RECOMMENDATION FOR PLANNING AND DEVELOPMENT COMMITTEE

APPLICATION REF: 3/2018/0435
GRID REF: SD 374247 441101

DEMOLITION OF EXISTING PROPERTY AND ASSOCIATED OUTBUILDINGS AND
ERECTION OF SIX DWELLINGS AT 32 HALL STREET, CLITHEROE, BB7 1HJ

PROPOSED PLANS AND ELEVATIONS FOR PLOT 4-6						
Site: HALL ST CLITHEROE						
Client: Mr Graham						
Date: 29.08.18	Scale: 1:100 @ A1					
Project No: GRAHA/01 Dwg 07C				Drawn: AxK		
Amendments:	A	B	C

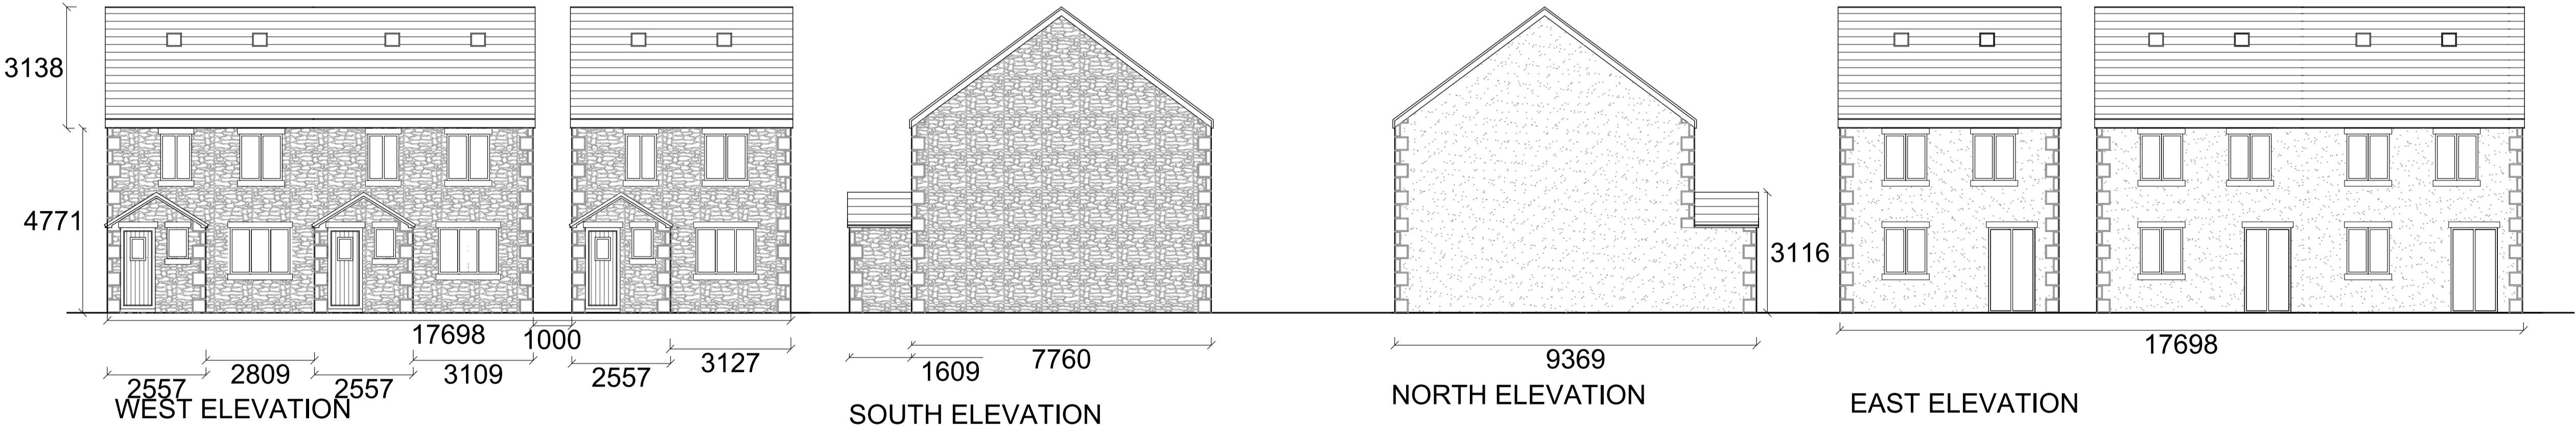
- 5.4.3 The proposed development would result in the two-storey gable elevation of plot no4 facing the rear elevations of 32-33 Copperfield Close. There would be a separation distance of around 13m which is considered as an acceptable distance from a blank two storey gable elevation to avoid any undue loss of light and outlook from facing habitable room windows. It is noted that the rear windows of properties along Copperfield Close currently provide views over the garden of no.32 Hall Street towards the bowling green and St James Church. However, the loss of a private view is not a material planning consideration.

- 5.4.5 A space of around 3.5m would be retained between the gable wall of the proposed dwelling and the rear garden boundary of 32-33 Copperfield Close. It is noted that there is a single storey conservatory to the rear of 32 Copperfield Close which projects closer to the boundary with the development site however conservatories are not classed as habitable rooms. In terms of any overshadowing of private gardens, applications will only be refused where a development would seriously overshadow private amenity space. Objections have been raised in relation to overshadowing of the private rear gardens of dwellings along Copperfield Close. However, these gardens are north-facing and whilst they may benefit from some limited morning sunlight the proposals would not result in overshadowing of large areas of garden for prolonged periods of the day to warrant refusal.

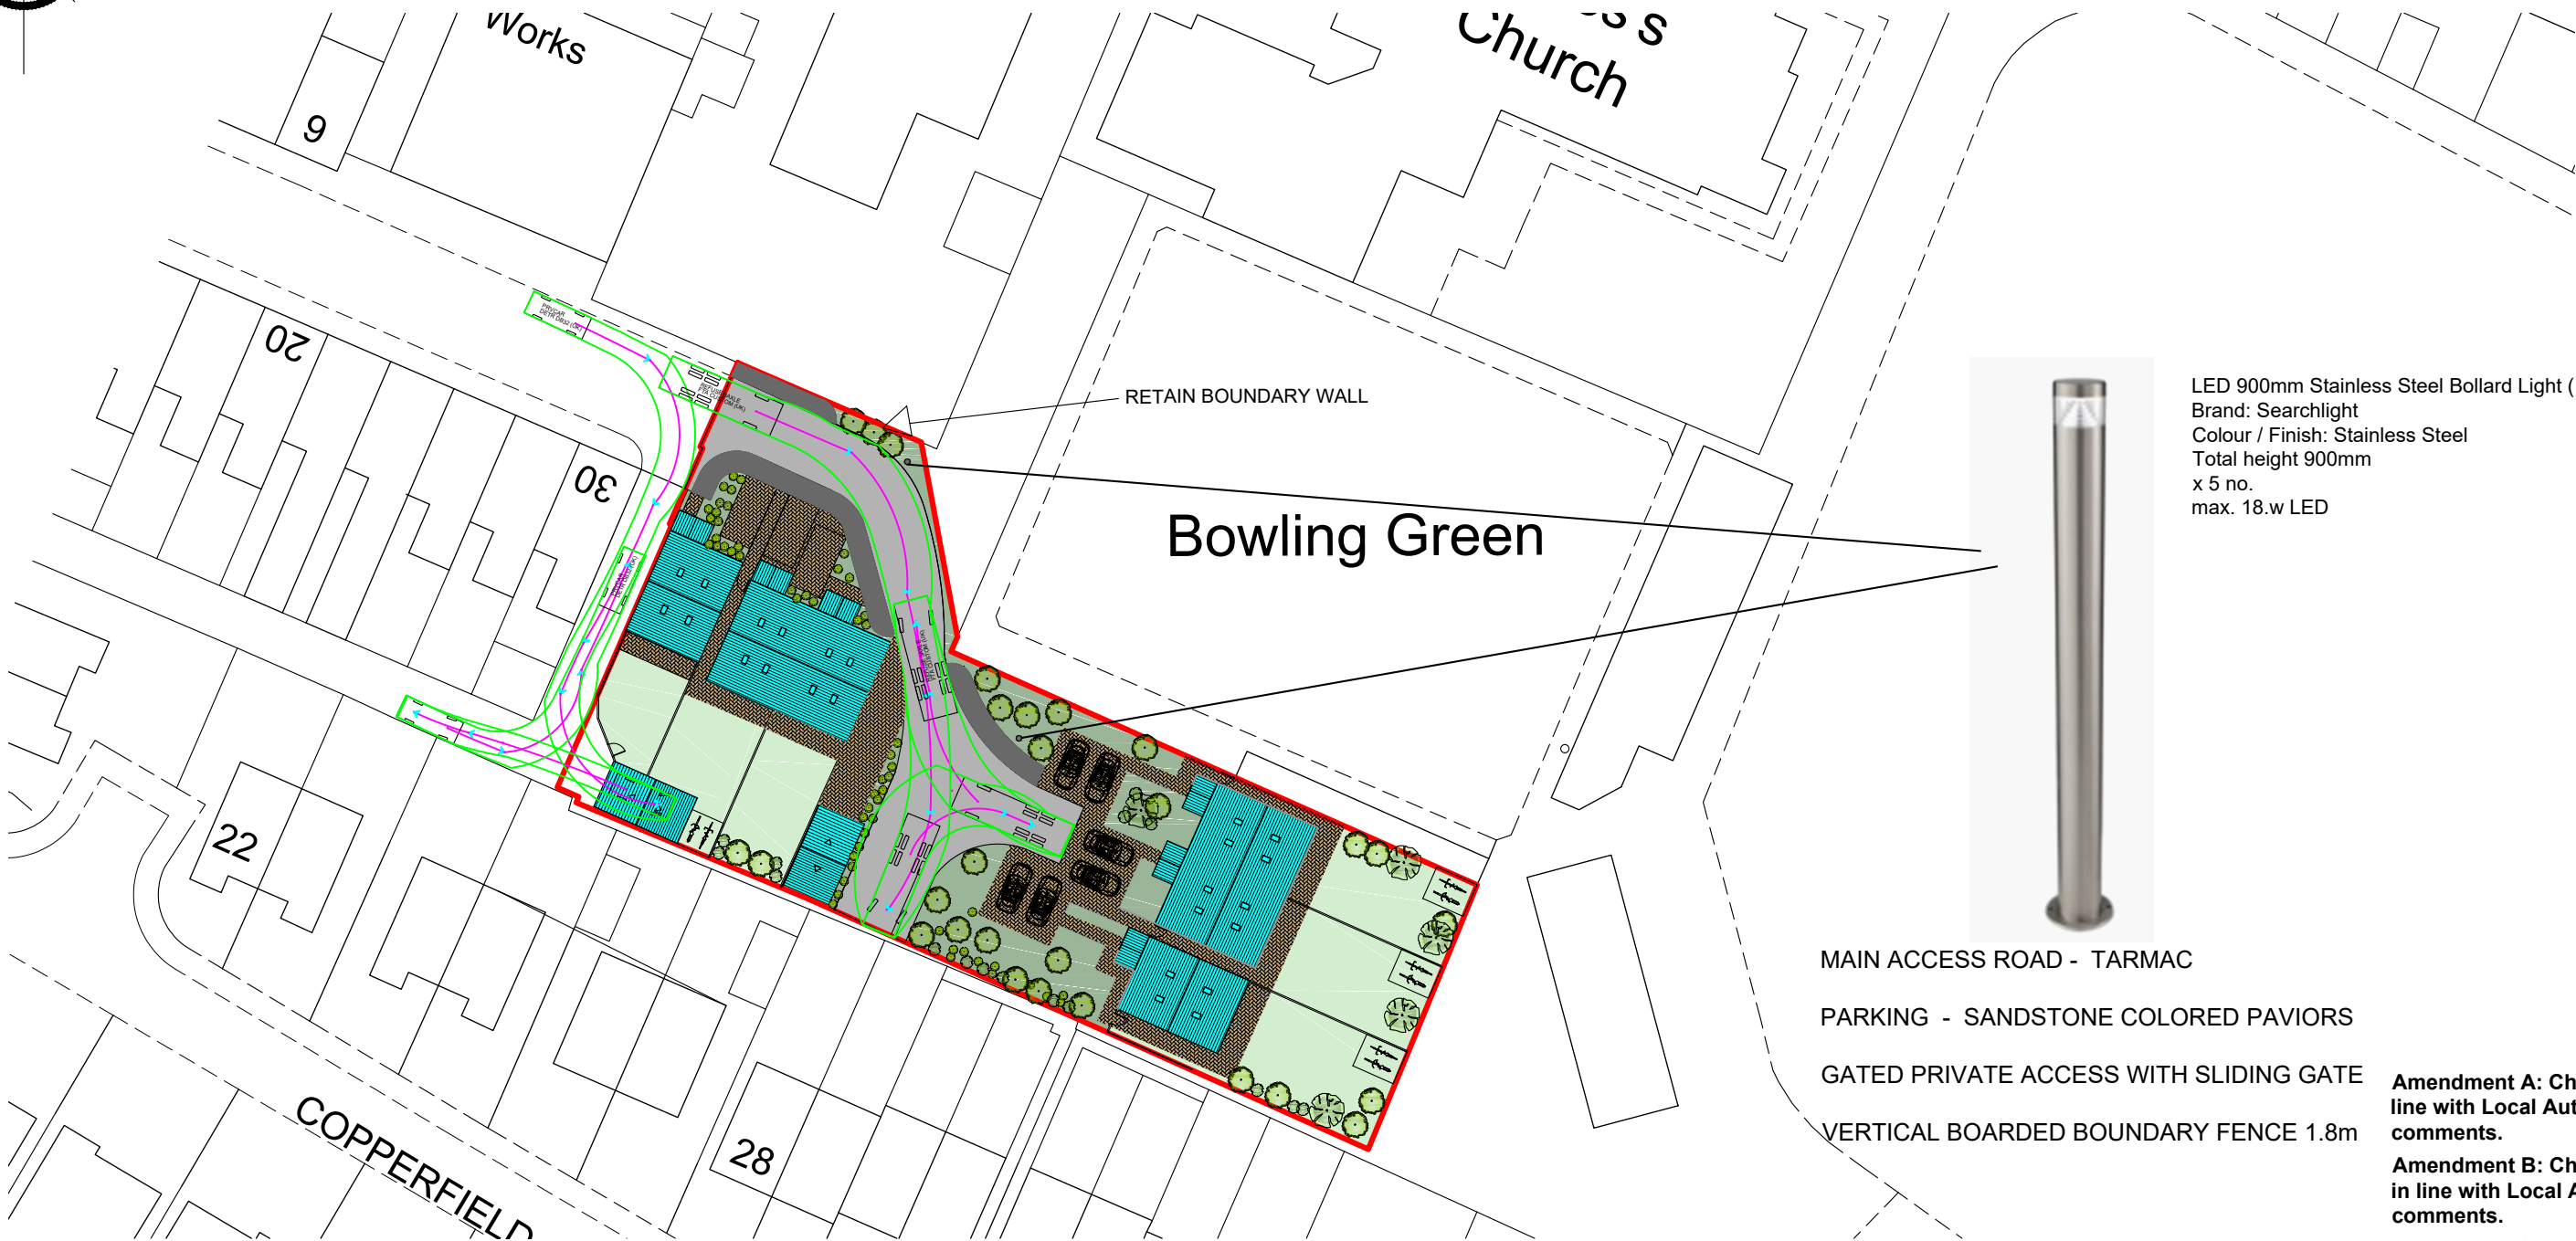
- The access from Hall Street, this should be widened to allow 2 cars to pass through the opened gate and beyond for a distance of at least two car park space lengths (9.6m).

- There appears to have been no provision made for pedestrians or cyclists to access the development without opening the main gate across the carriageway

- Nor does there appear to be any provision for pedestrians within the development.
- There is no provision for access to the rear of the plot at the gable of 30 Hall Street without passing through the dwelling.

- Nor has there been any indication regarding the provision of any street lighting or surface water drainage.
- A swept path analysis should be undertaken to ensure that a refuse collection vehicle can enter and exit the development in a forward gear.

- 5.6.2 The development will provide sufficient vehicular parking to serve the proposed dwellings and the County Surveyor has raised no concerns in relation to its impact on parking availability along Hall Street and Whalley Road. However, the County Highways Surveyor did raise some concerns relating to the lack of accessibility of the garage provided for plot no1 and the proximity of the parking space to the front door of plot no2.

address the concerns raised. An amended plan was submitted on 21st September in this regard (please note that neighbours have not been formally re-notified of the proposed amendments as it is not considered that the amendments would have a greater impact on the neighbours when compared to the previous scheme). The amended scheme results in the removal of the garage to Plot 1 gaining access to the back street, removal of the forecourt parking to Plots 1 and 2 and the replacement with garaging and parking spaces accessed from the internal turning head to the scheme.

This plan provides for garages for Plots 1-2, and the removal of the parking spaces to the front of the properties. All of the proposed garages are sufficiently large enough to be counted as parking spaces and should remain as such for the perpetuity of the development.

The parking space in front of plots 4-6 have also been altered from the initial submission access, although it is expected that they will still function.

- 5.6.6 The site layout does include the provision of a turning head within the development site which could accommodate a refuse wagon; there is no turning area available at the end of Hall Street at present and this would enable a refuse vehicle to enter and leave the site in a forward gear. The amended layout also includes the provision of a pedestrian footway into the development. The applicant would be required to enter into an appropriate legal agreement to provide off-site highway works including a new pedestrian dropped kerb at the gable of no.30 Hall Street to allow prams etc. to cross to the new dwellings.
